2023/0709

37 High Street, Penistone, Barnsley, S36 6BR

Change of use of single mixed use building to 2 separate units of hair salon and residential unit including addition of porch to residential unit

Title Floor Plans Proposed

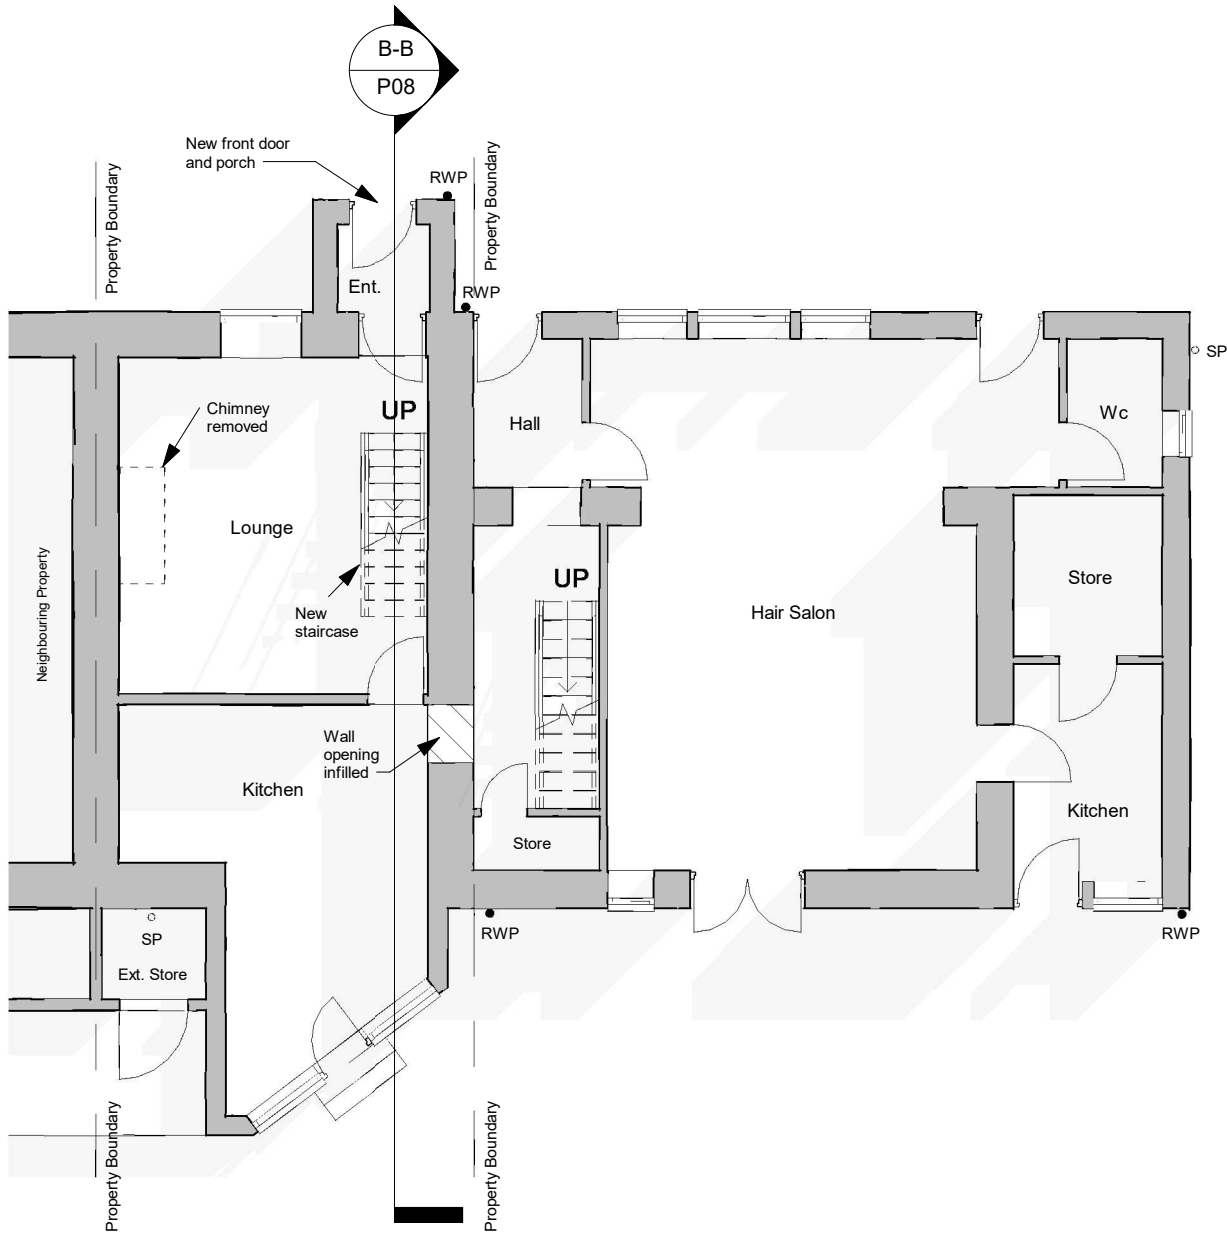
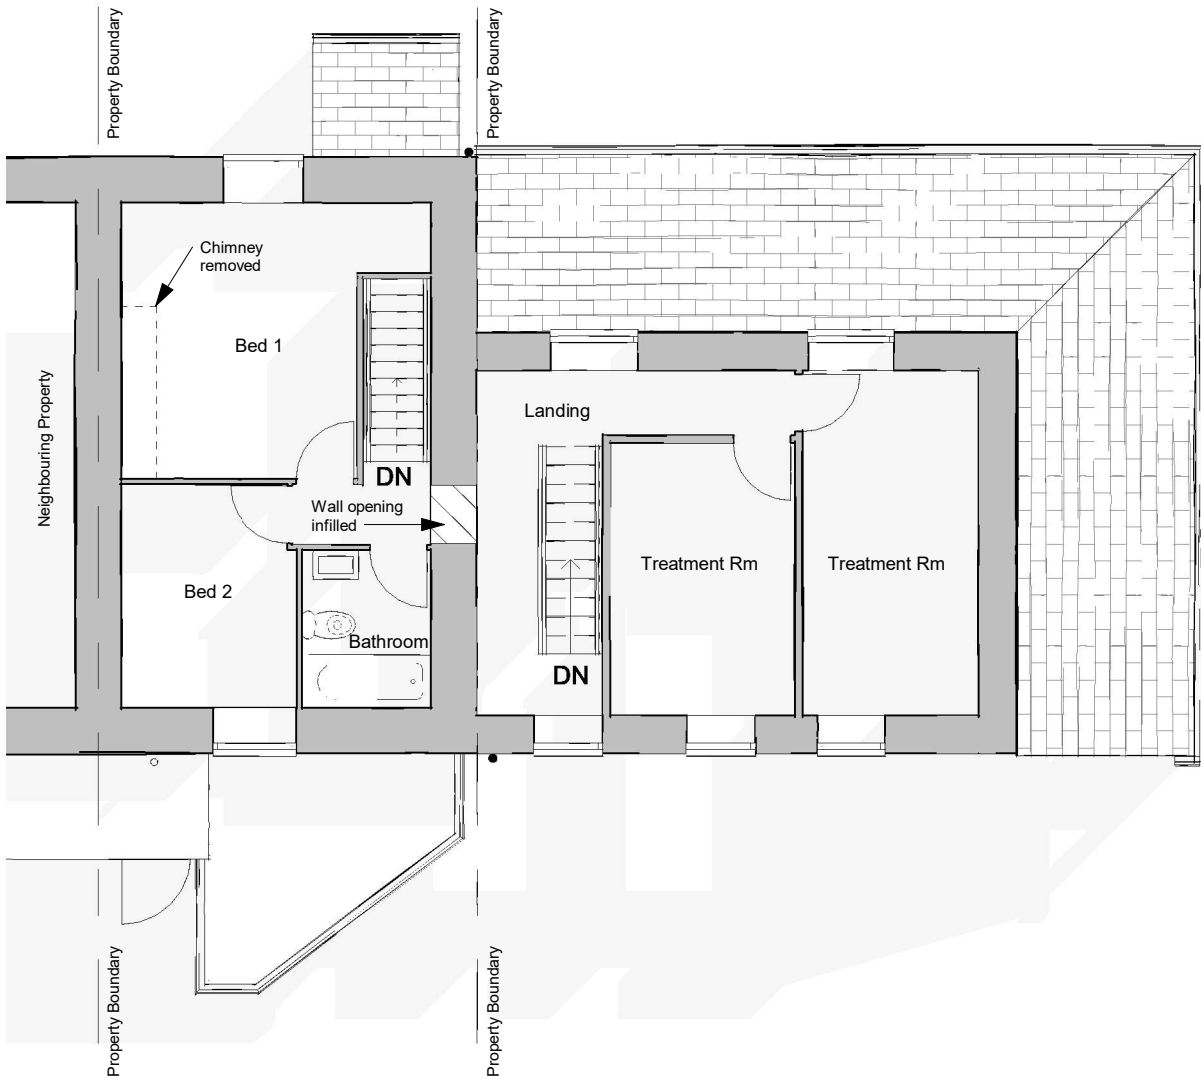
The proposal to sub-divide the building into separate units doesn't have any impact upon room sizes and spacing standards as these will remain as existing. The only difference will be the loss of a bedroom from the existing building as the bedroom formerly above the salon will now serve as extra rooms for the salon and be disconnected from the dwelling. The residential unit will now be two-bedroomed instead of three however it is still a two-storey dwelling and therefore not falling into the category of the least desirable dwelling type expected in the borough being 1-bedroomed flats.

There will be no impact upon highway safety. The proposal reduces the number of bedrooms in the residential element of the building from three to two. However, the salon space increases, with two new treatment rooms being proposed on the first floor.

Proposed
West Front
Elevation
Scale 1 : 100

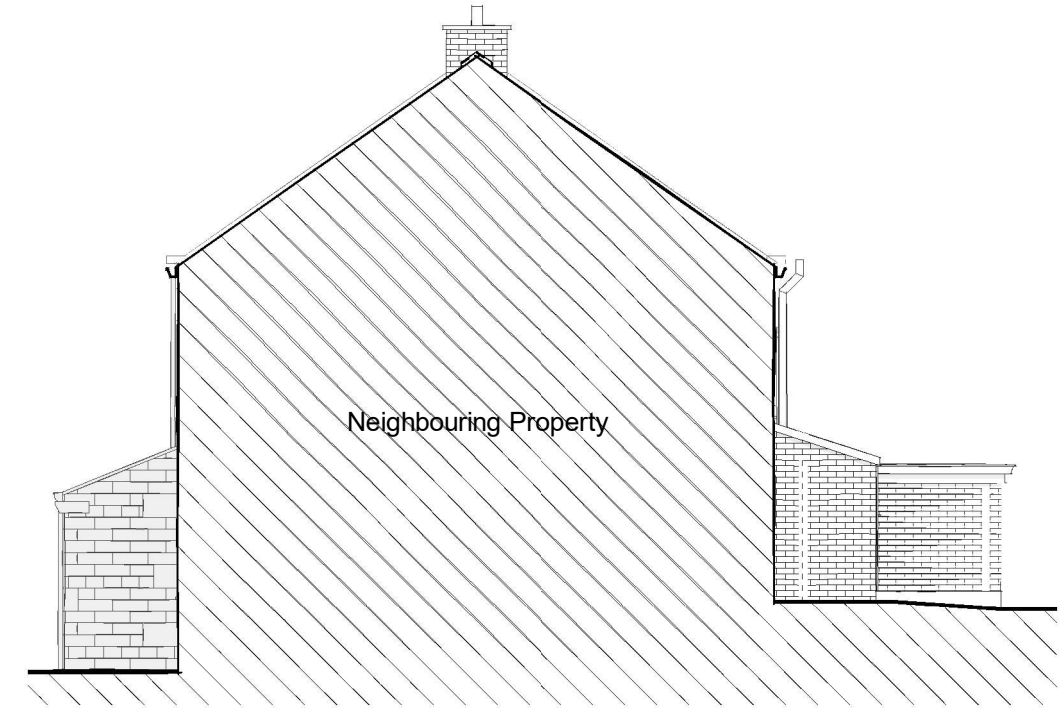
The proposal includes a front extension, and the front elevation is the most important elevation for its impact on the character of the street scene. The size of front extensions needs to be as modest as possible. There are porches of very low quality of design and materials in the vicinity, however these are neither complementary to nor historically typical of the conservation area. The size of proposed extension is acceptable, it complements the proposed dwelling's character and doesn't detrimentally affect the street scene.

In principle the porch is not entirely traditional as a feature but there is a precedent in the vicinity. As the lean-to roof is to be covered in stone roofing flags to match the main roof, this therefore follows the precedent for porches set elsewhere in the conservation area but with improved materials and design. The SPD states that *'materials should normally be of the same type, colour and texture to the existing house or as close a match as possible'*. In this case, the proposed materials will match the existing building with matching stonework and roof tiles being used. The extension utilises a mono-pitched roof which is akin to the existing building's pitched roof and therefore acceptable.

The proposed porch extension conforms to the SPD in terms of its external materials and roof type, therefore it will have little impact upon the character of the street scene due to the harmony with the existing building and its modest size and scale. The proposed development is therefore not considered to be contrary to Local Plan Policy D1: High Quality Design and Place Making and is considered acceptable in terms of visual amenity.

The proposed front extension will not have a significant detrimental impact on any neighbouring property by way of overshadowing or being overbearing. This because of the modest projection of the front extension which is only 1.55 meters. In terms of overlooking no windows are proposed on the side elevations of the extension. The proposal is considered to be in compliance with Local Plan Policy GD1: General Development and is acceptable in terms of residential amenity.
